February 13, 2022

Subject: Comments regarding the "Cape Driveway Improvement project" (SE-22-00002 Cape)

Soil Map—Kittitas County Area, Washington

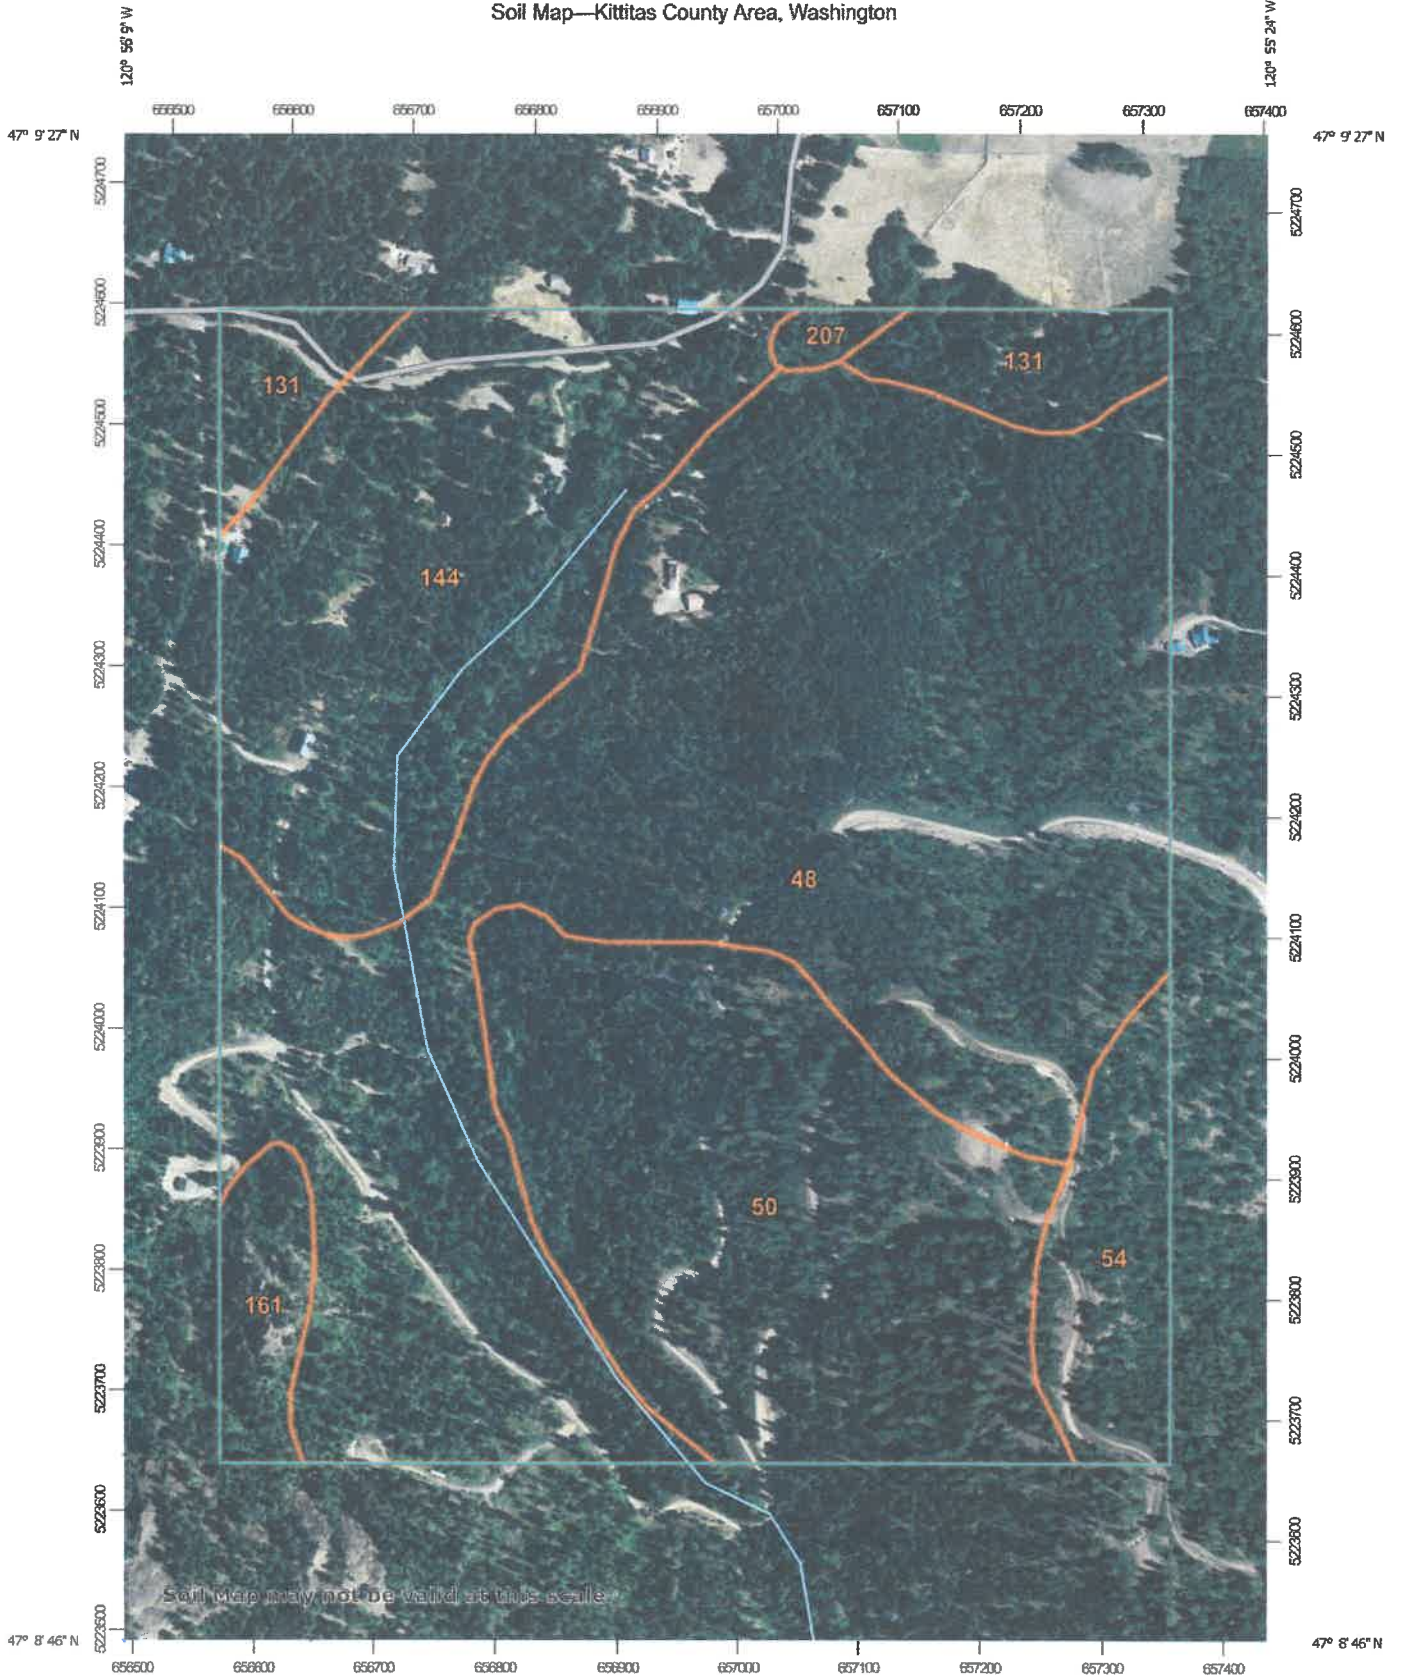
The applicant’s response to B.1.b states that the steepest slope on the site is “Approximately 16%.” However, the soil map accompanying the SEPA checklist identifies that about 80% of the project area is characterized by soils with 45-65% slopes. The property report for parcel 19162 states that it contains slopes >30%. And in B.8.1.h, the applicant acknowledges that a portion of the road is in a hazardous slope area. Inspection of hazardous slope areas on COMPAS 3.0 indicates that much of the upper portions of the road are in hazardous slope areas.

Parcel #19162 Driveway Improvement Extents

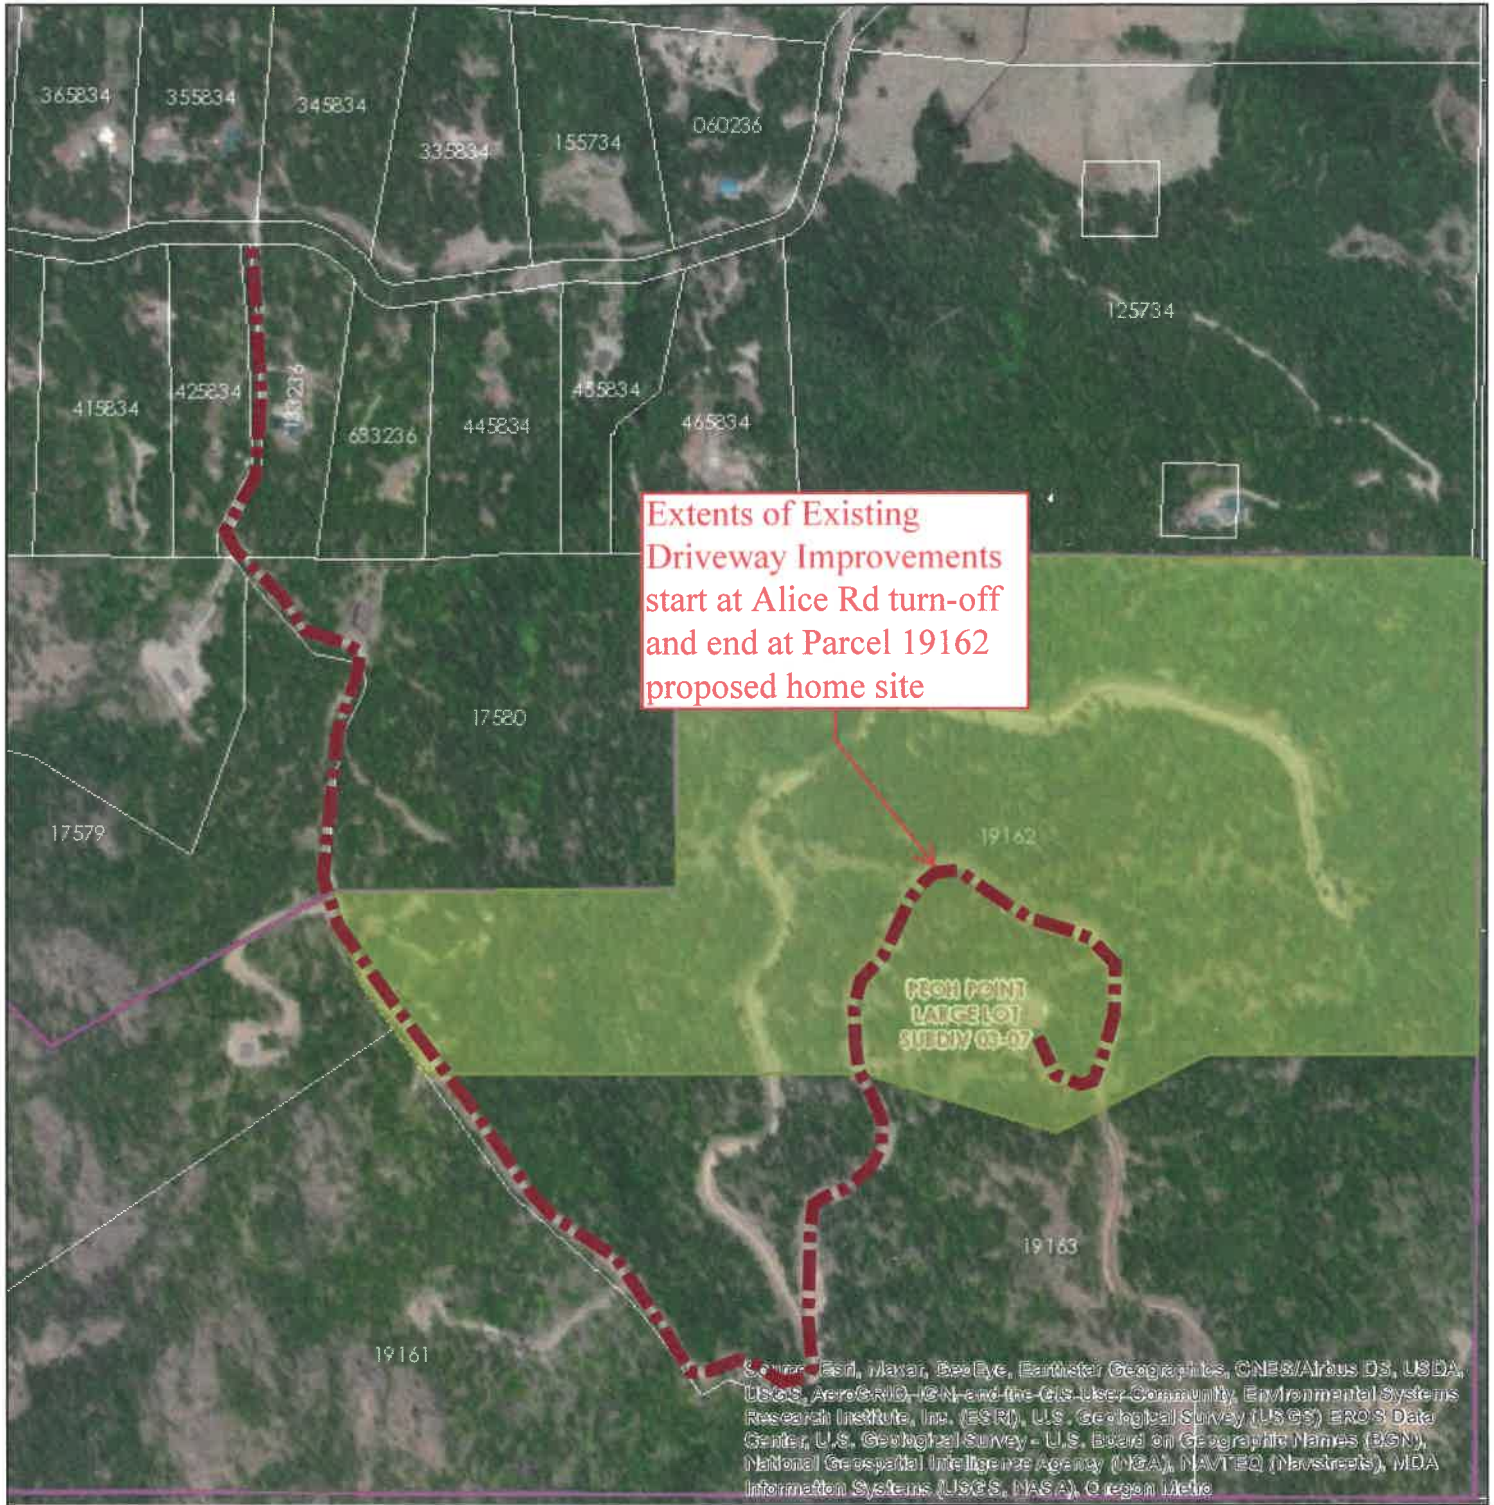
The proposed project is repeatedly described in this and subsequent sections of the SEPA checklist as a "driveway improvement" for parcel 19162; and in B.14.f it is described as an "existing driveway that serves four parcels." This is a misleading and inaccurate characterization. As can be seen on the extents that accompany the SEPA checklist, and according to online County GIS data, the access road serves 9 separate parcels owned by 8 different property owners:

The extents accompanying the SEPA checklist identify approximately 1.34 miles of “driveway” that is proposed to be paved, of which more than 60% runs through these other owners’ properties, *not* on the applicant’s parcel. This raises fundamental questions about whether the applicant has any right to alter and independently pave a road through someone else’s private property, and whether the County can permit such action without the affected owners’ consent?

The proposed paving project does not meet at least two of the County’s minimum design standards for a Private Road. Along the lower segment of the road, where it accesses Alice Road, the right of way easement is only 30’ wide, and the adjacent property owners have expressed their opposition to any widening of that easement through their property (see letters from Jon Osterberg dated February 3, 2022 and Rob Thayer dated February 8, 2022). The grade along this lower segment of the road is more than 13%, and additional sections in excess of 10% grades would be required for the proposed road to make its >800-foot ascent above the base elevation at the intersection with Alice Road. We note that a similar attempt to “improve” this access road in the early 2000’s fell through when County road standards could not be met.

to B.1.f states that “erosion is not anticipated due to the controls that will be in place during the work including a stabilized construction entrance, covering of stockpiles, and silt fence as needed.” However, no engineering, design drawings or detailed plans are presented to demonstrate how and where specific controls would be deployed to comply with County requirements and to ensure that erosion and stability impacts are effectively avoided, minimized or mitigated.

We are concerned that if stream culverts are inadequate for handling peak flows, streams could become blocked or diverted and create risks of flooding, washout, or erosion on the road and adjacent properties. The SEPA Checklist does not include any engineering, design drawings or other information to show how the proposed project will comply with County requirements regarding drainage structures and ensure that these stream crossings, especially during peak flows, will not be impeded.

With respect to stormwater runoff, the applicant states in B.3.c.1 that “no changes to water runoff including stormwater are proposed as part of the improvements” despite earlier reference in A.11 that the project would include “re-establishing [sic] and installing new drainage swales as needed.” But no engineering, detailed drawings or other information was included with the SEPA checklist to demonstrate how drainage along the road would be designed and constructed to comply with County stormwater requirements and design standards, and ensure adequate and safe conveyance of stormwater.
